Recommendation Report for Planning Permission for Works or Extension to a Dwelling

REF NO: FP/55/19/HH

LOCATION: 5 Normans Drive
Felpham
PO22 8LW

PROPOSAL: Proposed ground and first floor extensions and alterations (Resubmission)

1003-02

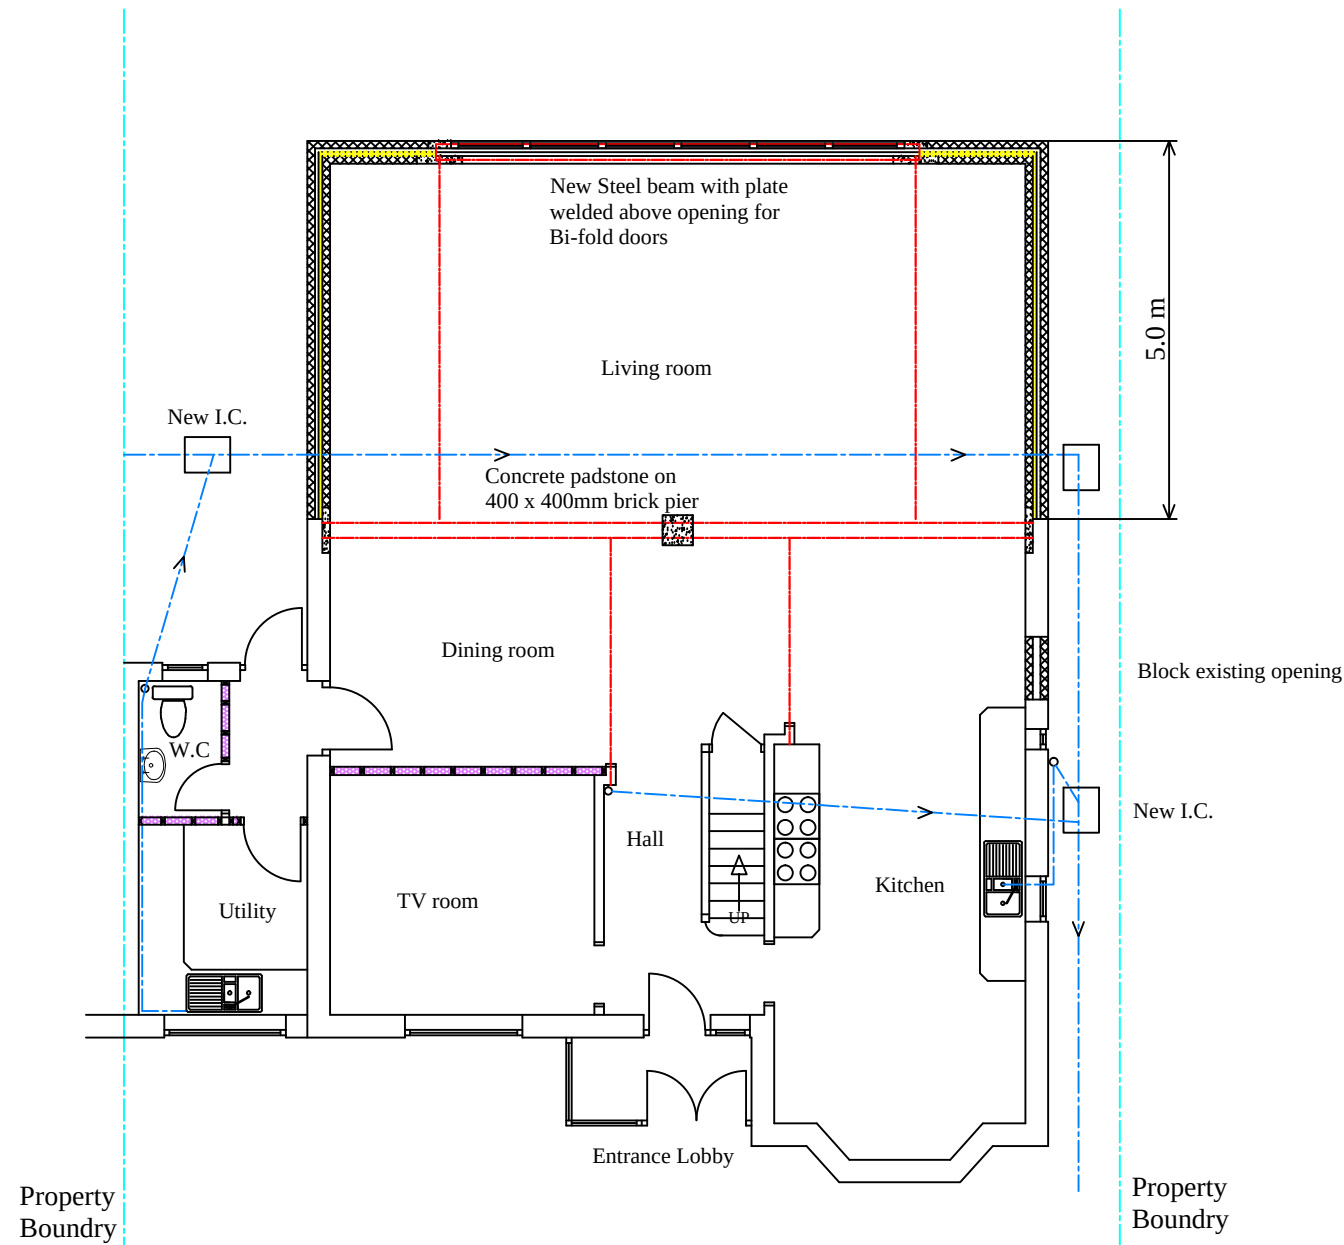
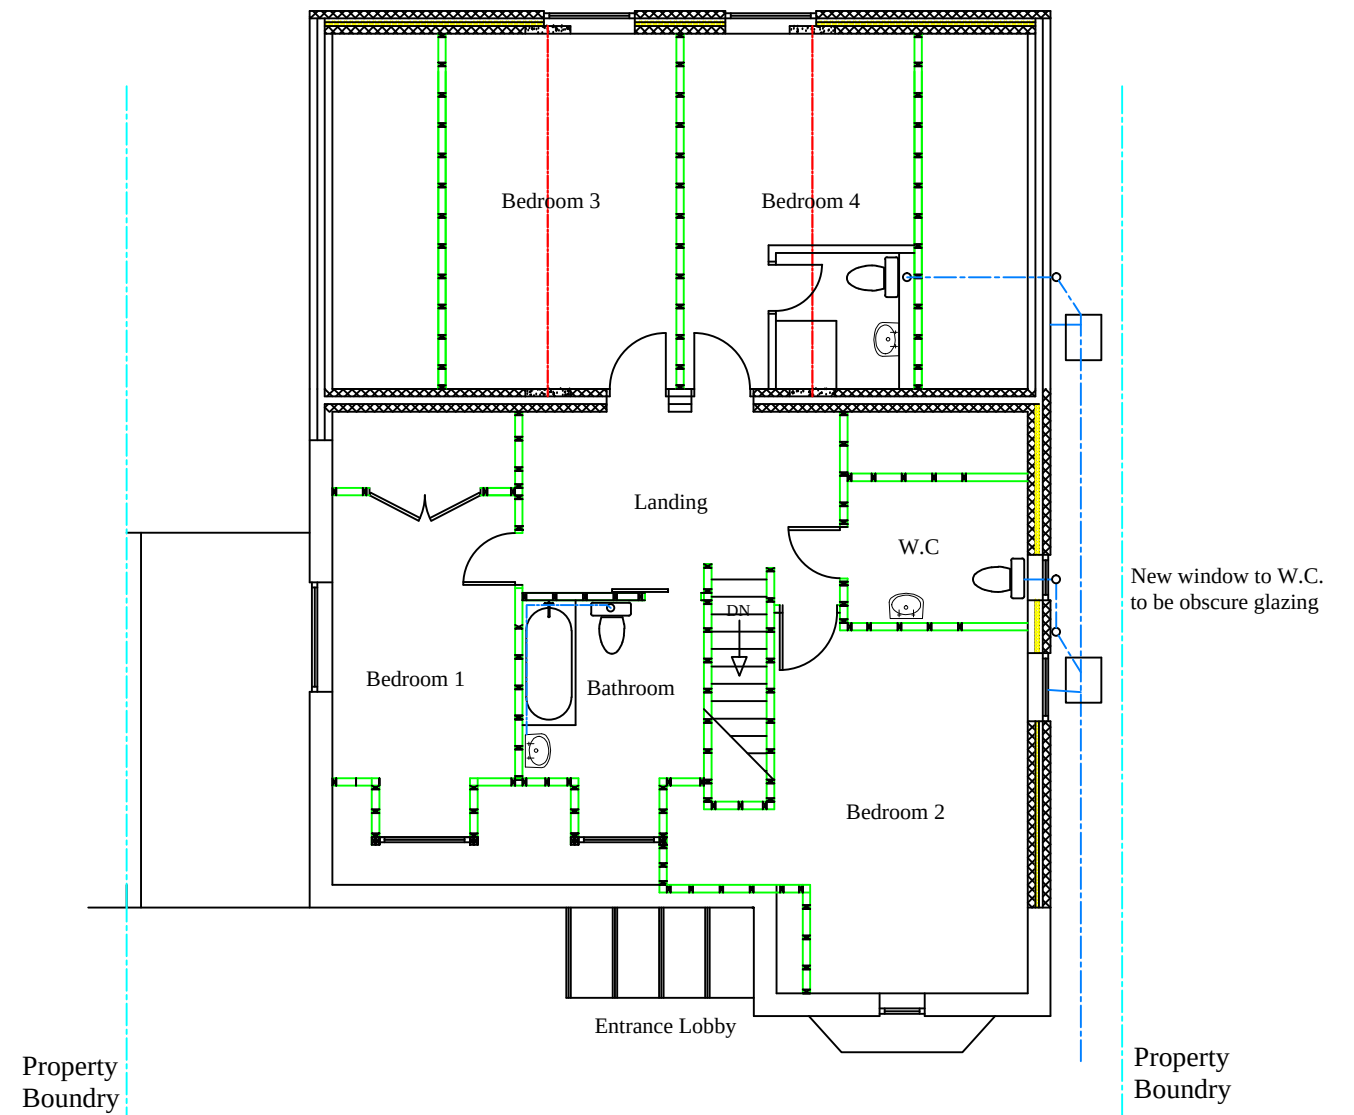
The alteration will involve the removal of the first floor side extension. To the rear there will also be a

reduction in the width of the rear extension. As a result of the reduction in width and removal of a side extension, the development will no longer extend beyond the southern side elevation of the host dwelling and therefore the separation distance will be retained to that of the neighbour to the south with 2.7m to the boundary line. As a result of the revised siting the alteration is not considered to give rise to any adverse impacts upon neighbouring amenity.

To the first floor rear elevation there were 3 windows proposed however this will reduce to 2. It is not considered to result in any adverse overlooking additional to that which has already been approved with sufficient space retained to the rear and side boundaries. An additional window is also proposed to the northern gable end. This will serve a bathroom and will be obscured glazed as shown on the plan. With 1 window already in existence and due to the siting it is not considered to give rise to any adverse overlooking upon the neighbouring property.

PROJECT	
Proposed Ground, First Floor Extension & alterations 5 Norman's Drive, Felpham, Bognor Regis, PO22 8LW	
TITLE	
Proposed Elevations	
CLIENT	
Mr Adam Ferrier	
SCALE	DATE
1: 100	03/04/2018
DRAWING NO.	rev.
1003-04	08/03/2019

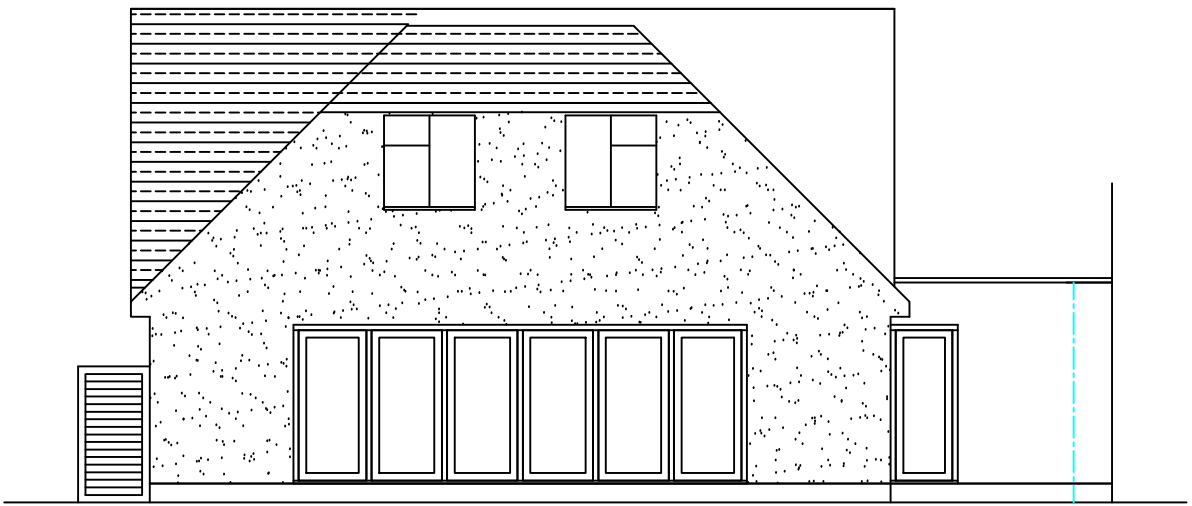
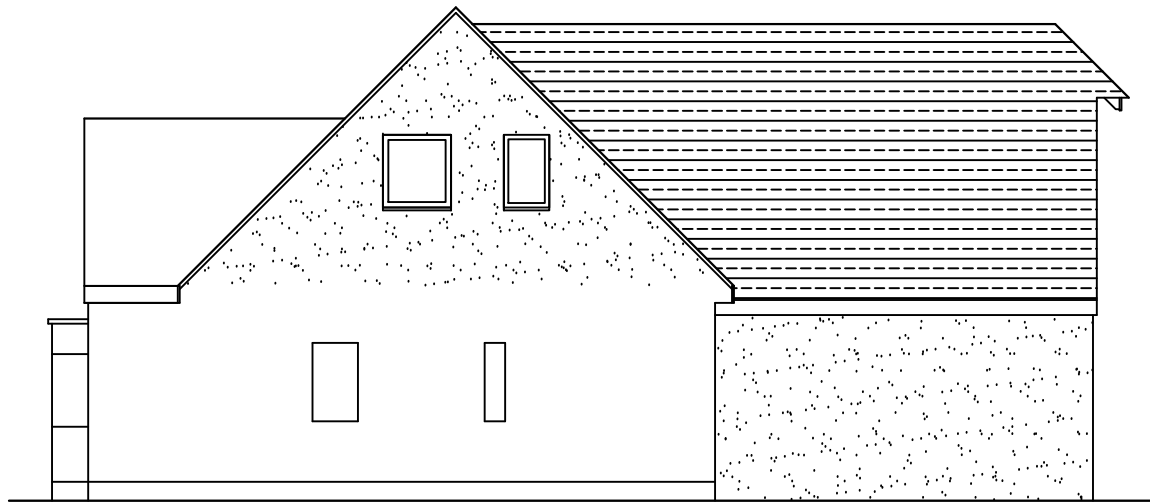
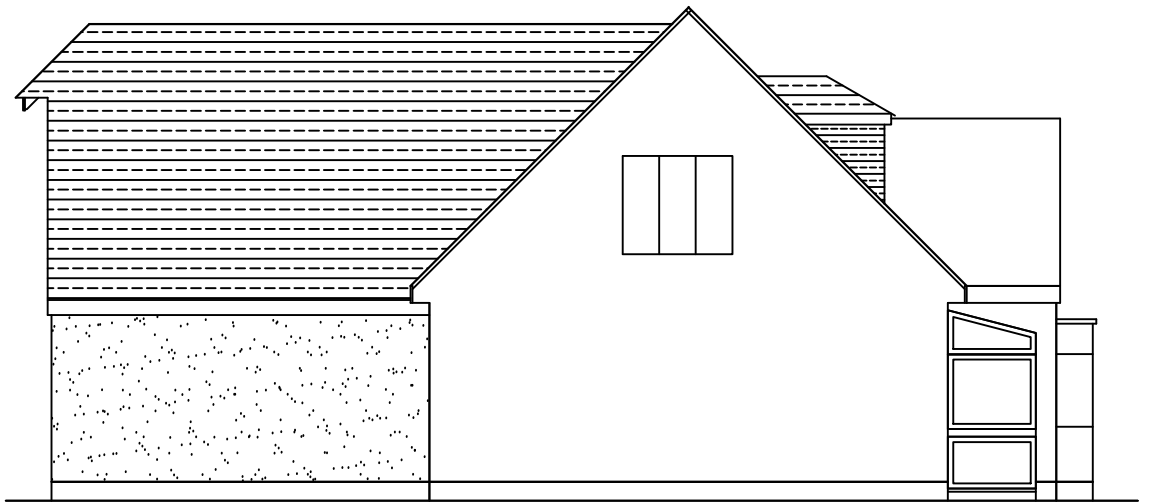
There is currently a single storey extension to the side of the dwelling. By removing the first floor element this will retain the existing separation between the host dwelling and that of the neighbouring property at No.3. Part of the development is visible from the street scene however the removal of the first floor extension this will reduce that which is visible from the wider area and as such it is not considered to adversely impact upon the spatial pattern or character of the area and accord with DDM1 and DDM4 of the Arun Local Plan.
